SSD_7056: CAMPBELL'S STORES, THE ROCKS

MODIFICATION REPORT BAY 11

URBIS

Drawing Title  
**GROUND FLOOR**  
JPW Project Number  
**12006**  
Drawing Status  
**EA**  
Drawing Number  
**EA-A-1001**  
Revision  
**D2**

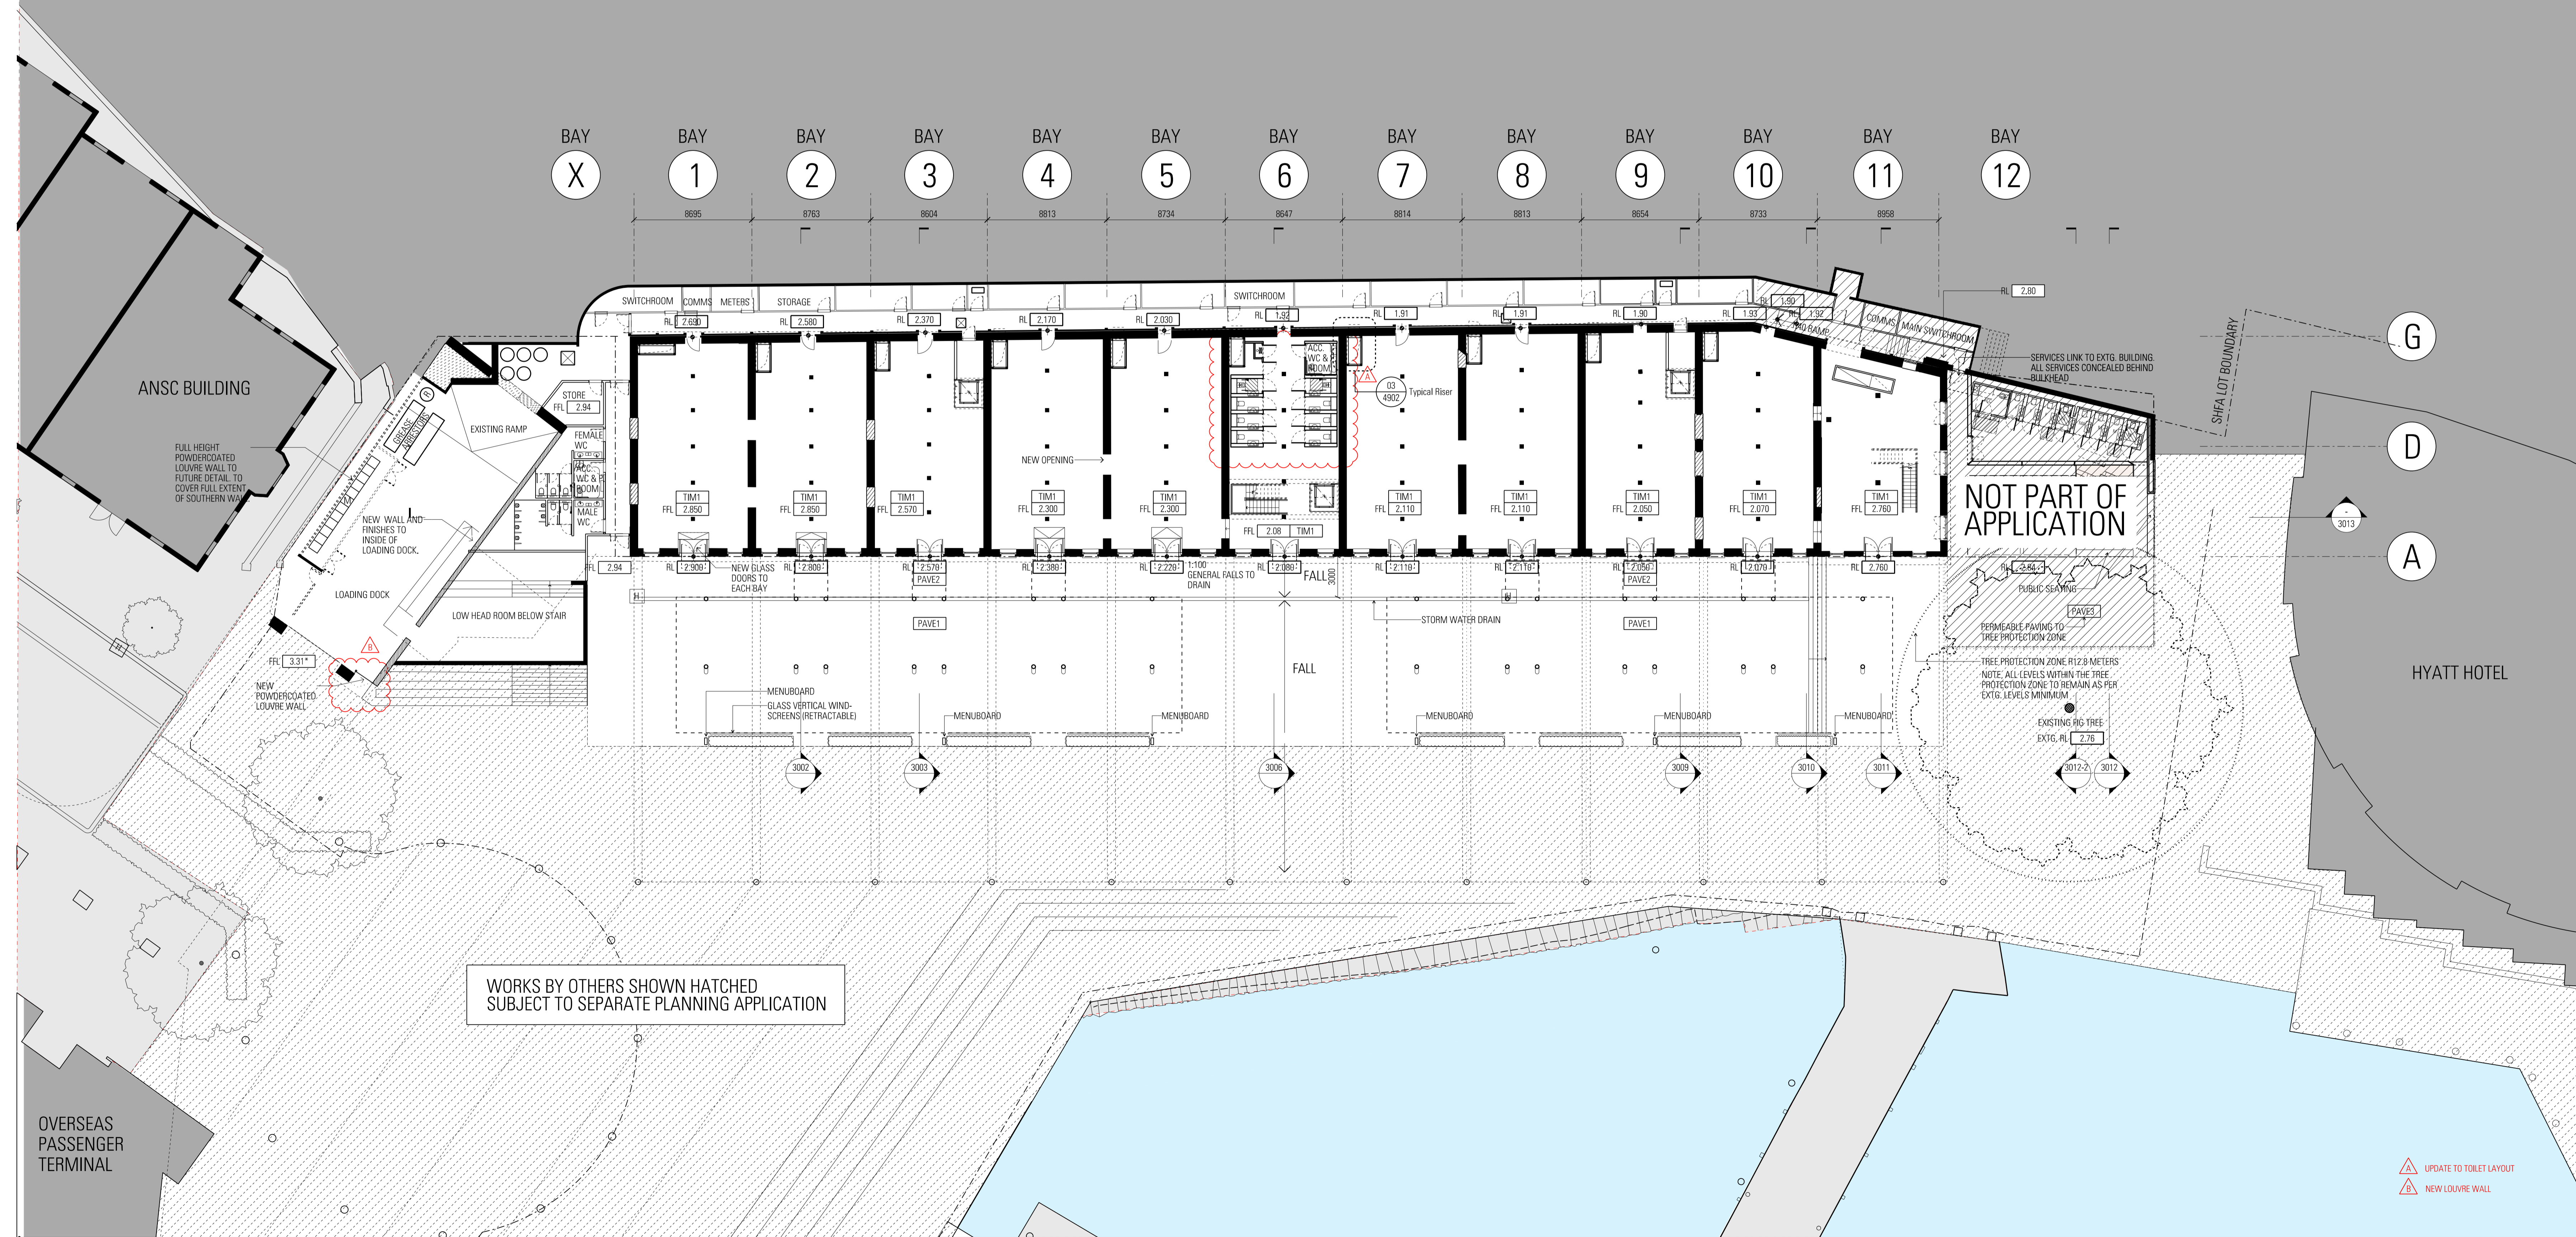
A new powder-coated louver wall has been added to the loading dock adjacent to Bay X stair to allow for improved mechanical ventilation. A comparison of the approved and modified loading dock wall is provided at Figure 3.

The toilet layout within Bay 6 at Ground Level has been refined and simplified during design development. The total number of toilets have not changed, including provision for accessible toilet facilities. A comparison of the approved and modified toilet layouts is provided at Figure 4.

Drawing Title  
**ROOF PLAN**  
 JPW Project Number  
**12006**  
 Drawing Status  
**EA**  
 Drawing Number  
**EA-A-1006**  
 Revision  
**D2**

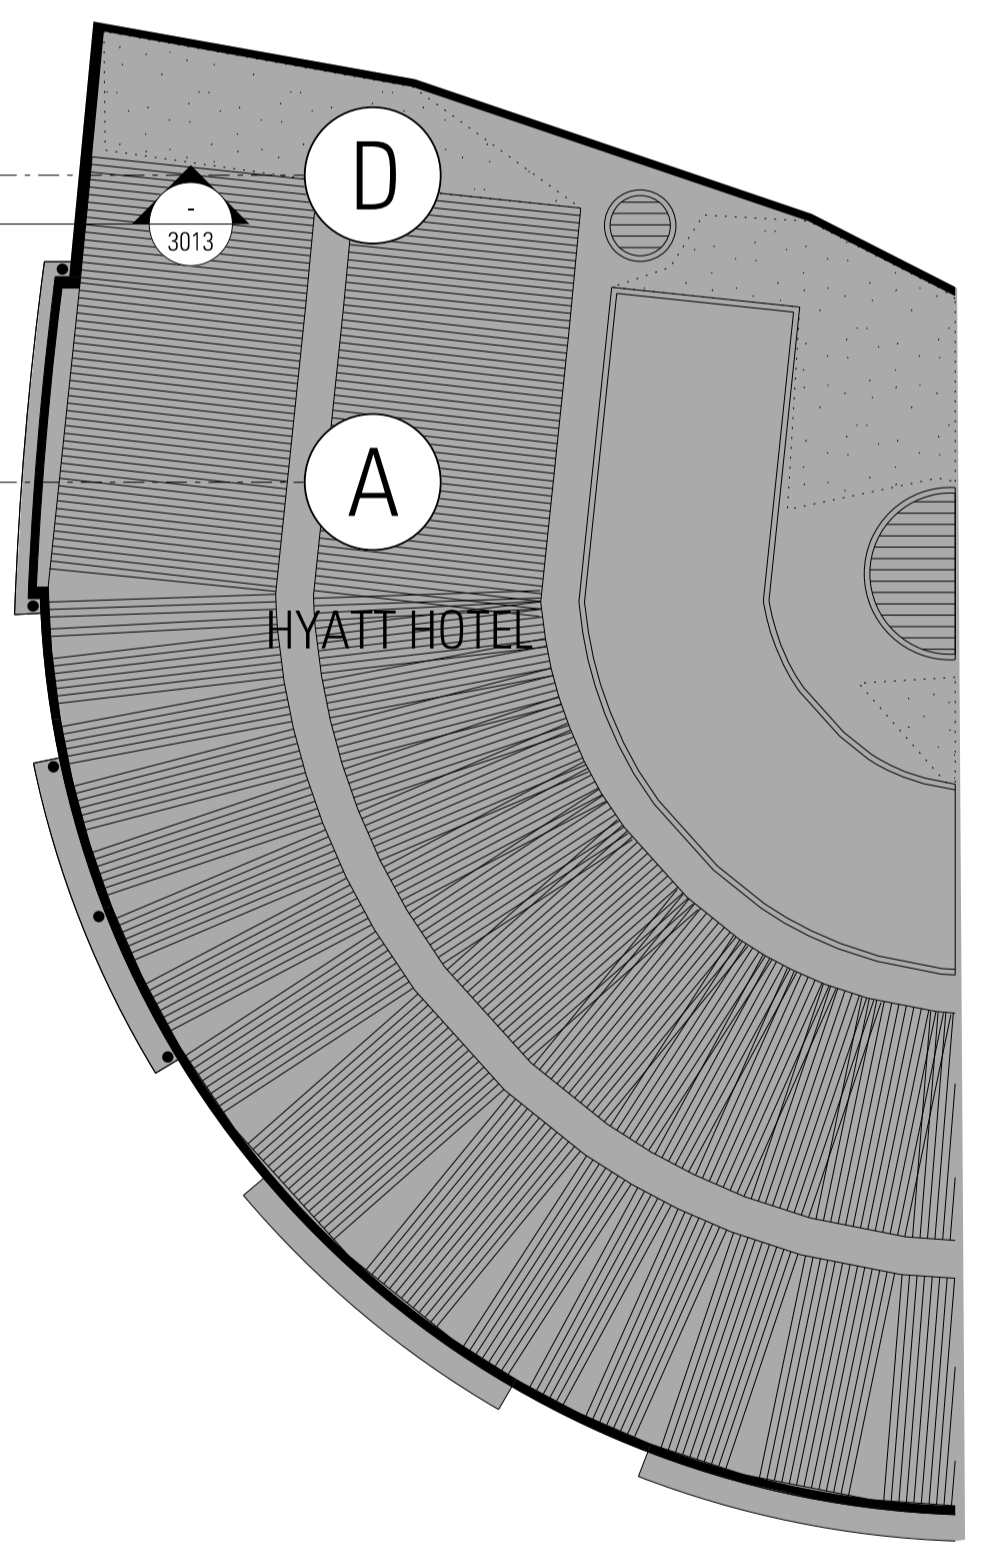
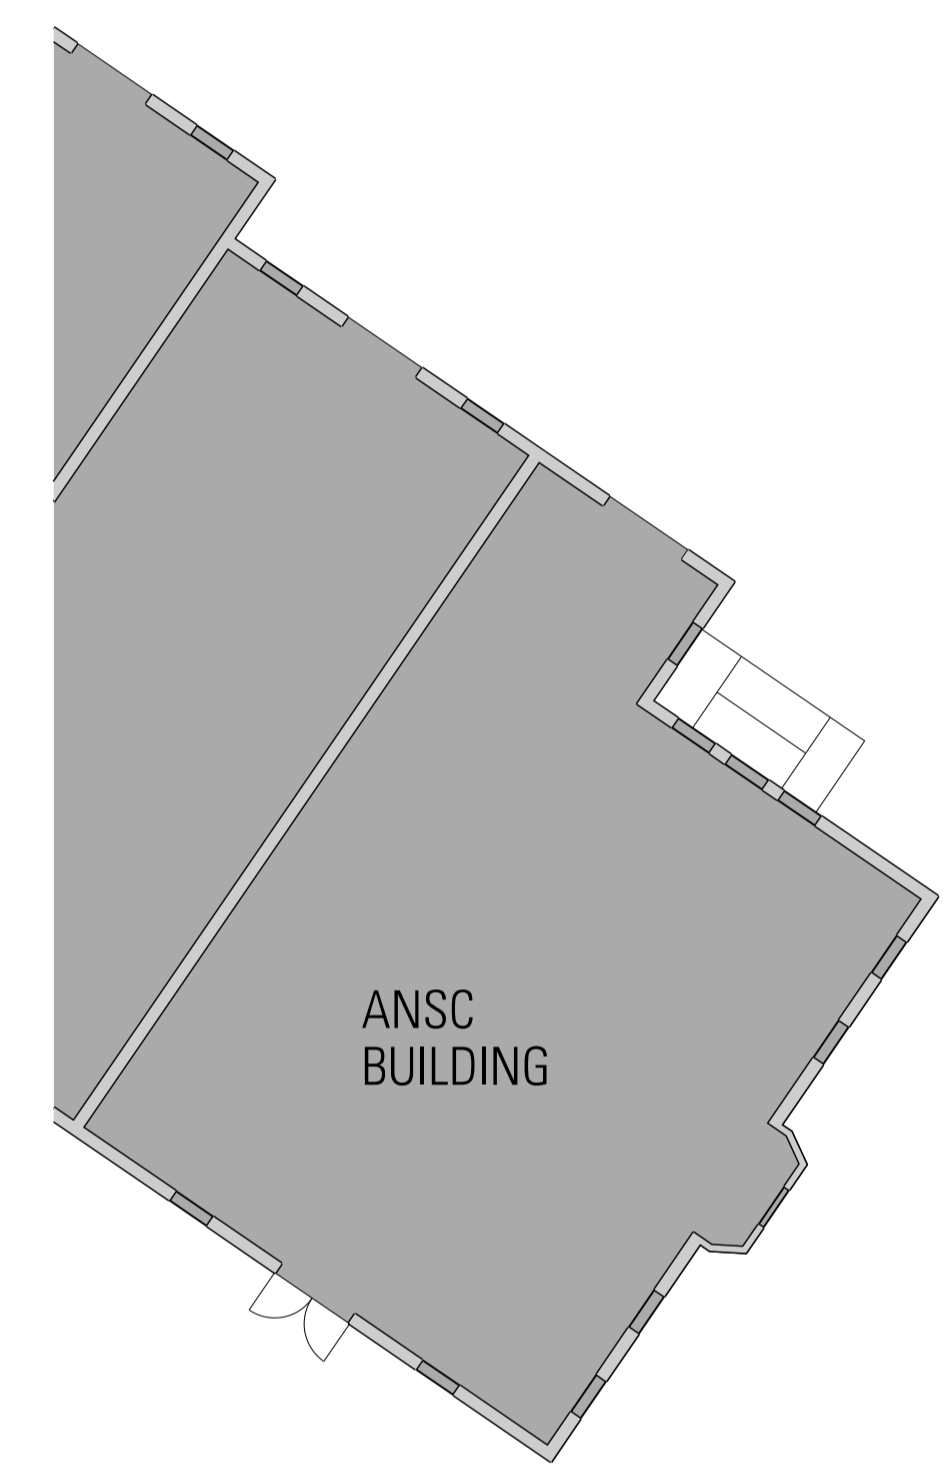
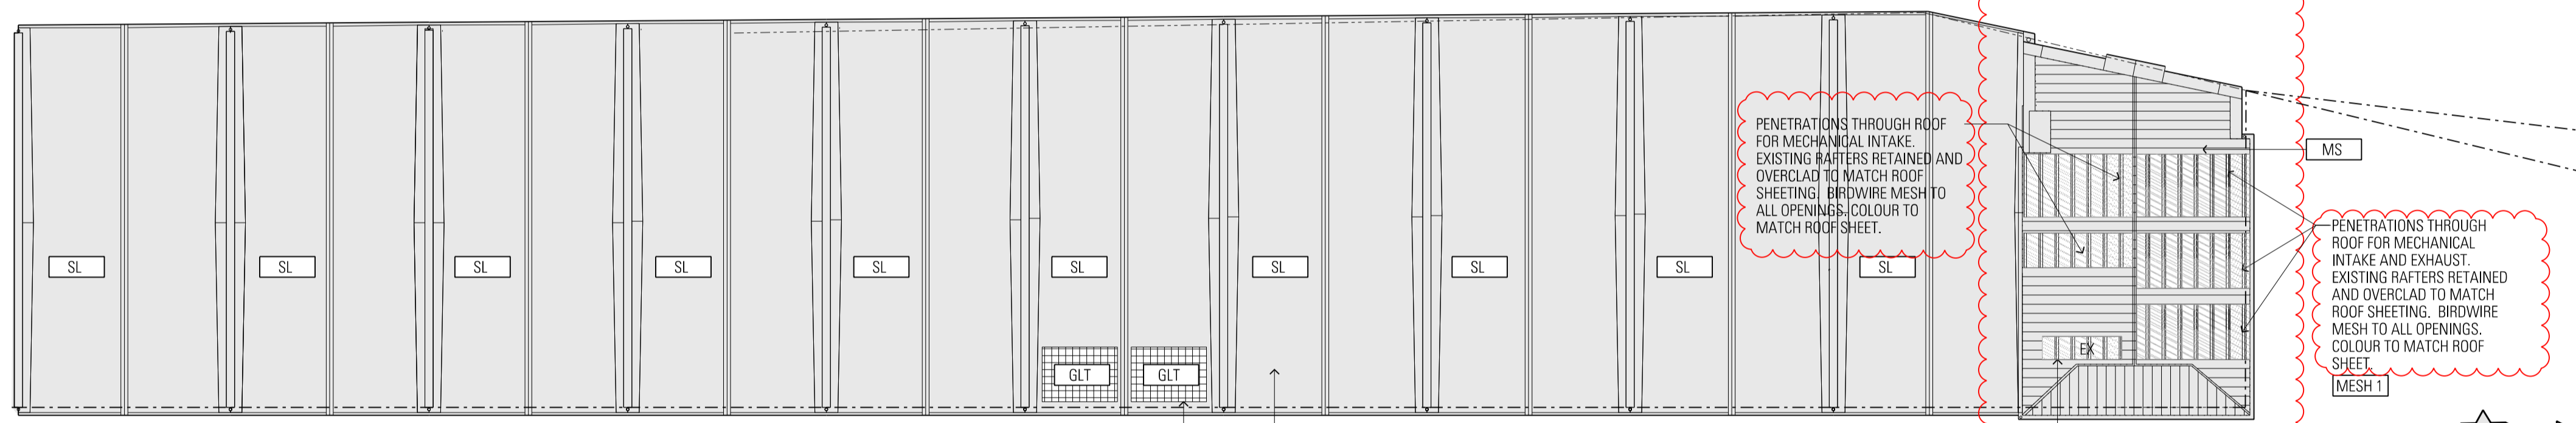
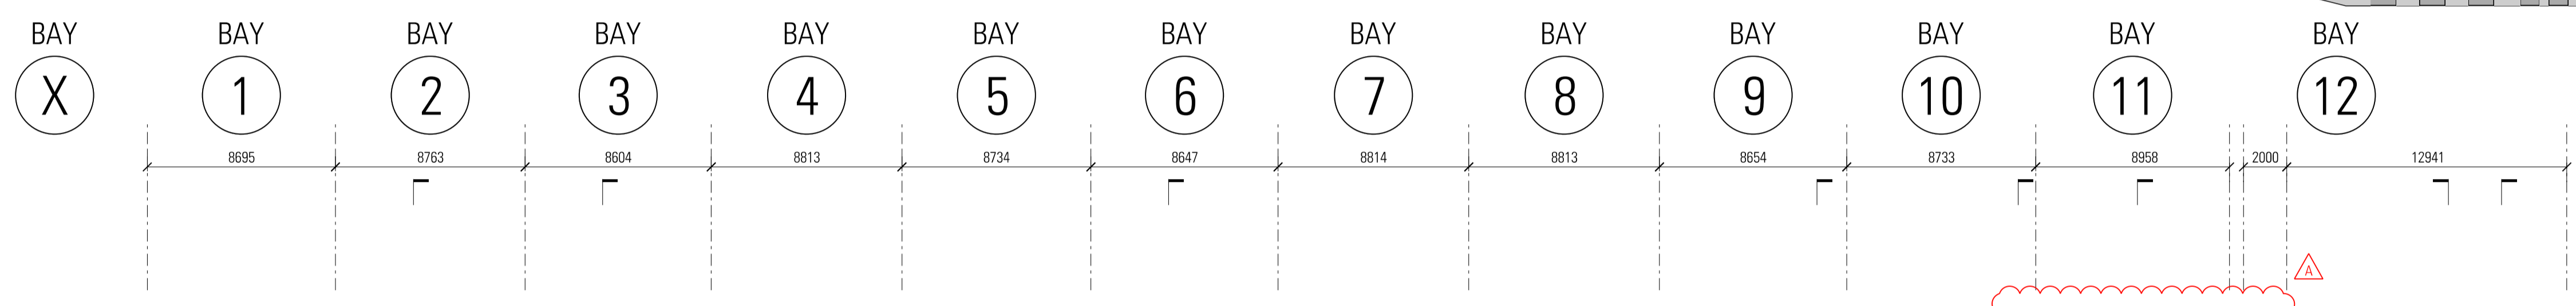
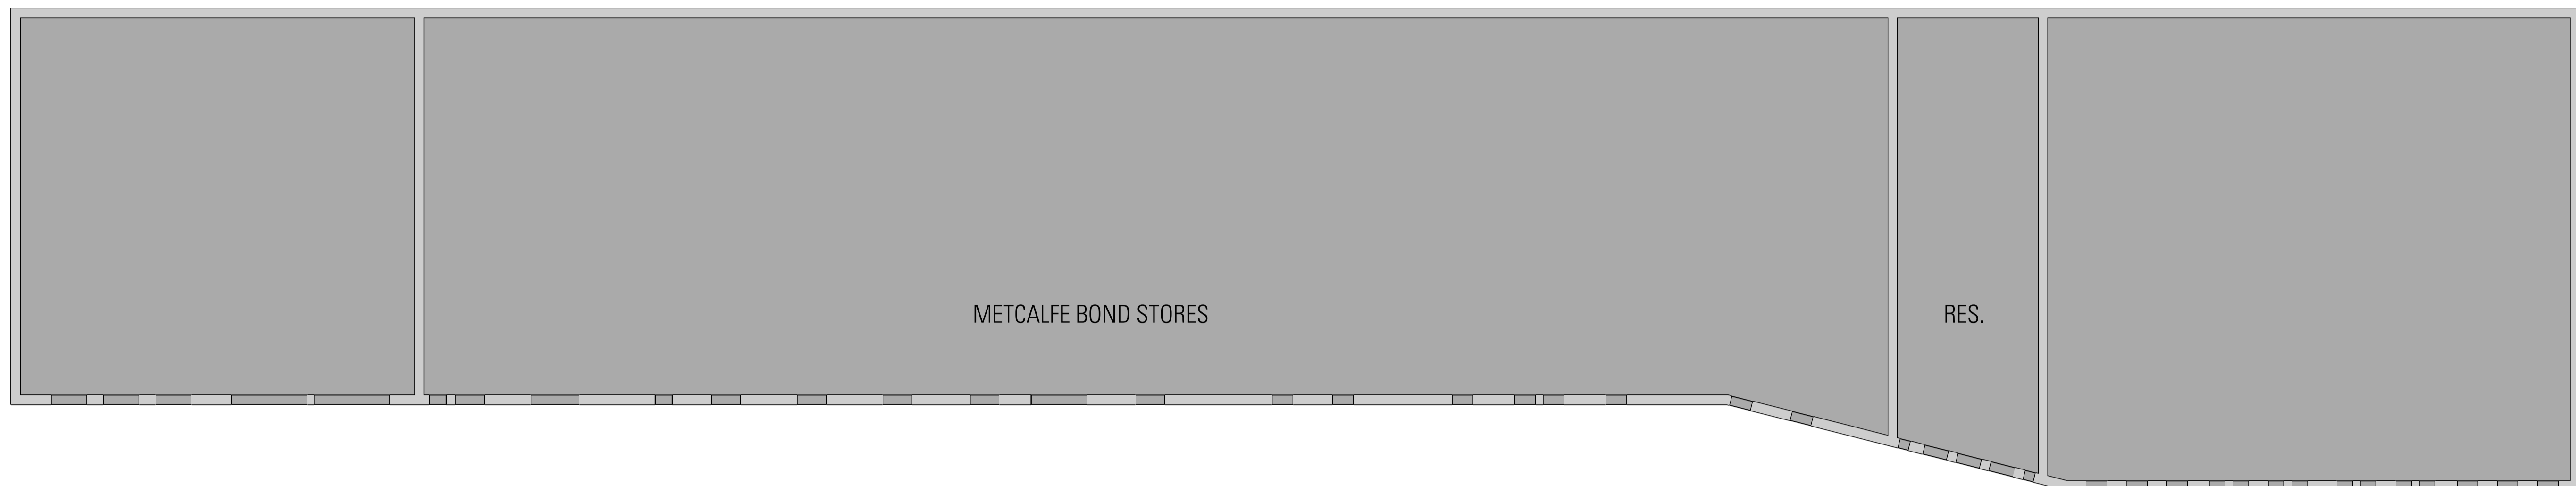
SSD_7056 provided approval for the removal of the existing mechanical exhaust system throughout Campbell's Stores and construction of a new centralised exhaust system within the roof of Bay 11, including penetrations in the roof structure to allow for natural ventilation of the plant room. During design development, mechanical engineers identified a need to amend the proposed mechanical ventilation system from an electrical generated system to a gas fired system due to the lack of sufficient electrical power at site.

The alternative gas fired system requires a minimum area of free air and therefore necessitates larger openings in the new Bay 11 roof sheeting, than was approved by SSD_7056. Consequently, this Modification seeks consent for alterations to the Bay 11 plant room and roof structure to allow for the refined mechanical ventilation system.

- The current approved design accommodates mechanical equipment within the roof space of Bay 11.
- The current approval has air intake and exhausts via openings in the new roof cladding of Bay 11.
- The roof cladding is not original fabric and is an approved replacement.
- The use of a gas fired system necessitates larger openings in the new roof sheeting, requiring a minimum area of free air.
- In order to minimise the visual impact of the larger openings, a fine mesh is proposed to cover the openings, the colour of which is to match the roof sheeting.
- All equipment and roof structures within the roof space are to be painted a recessive colour, to match the roof sheeting colour of Bay 11.
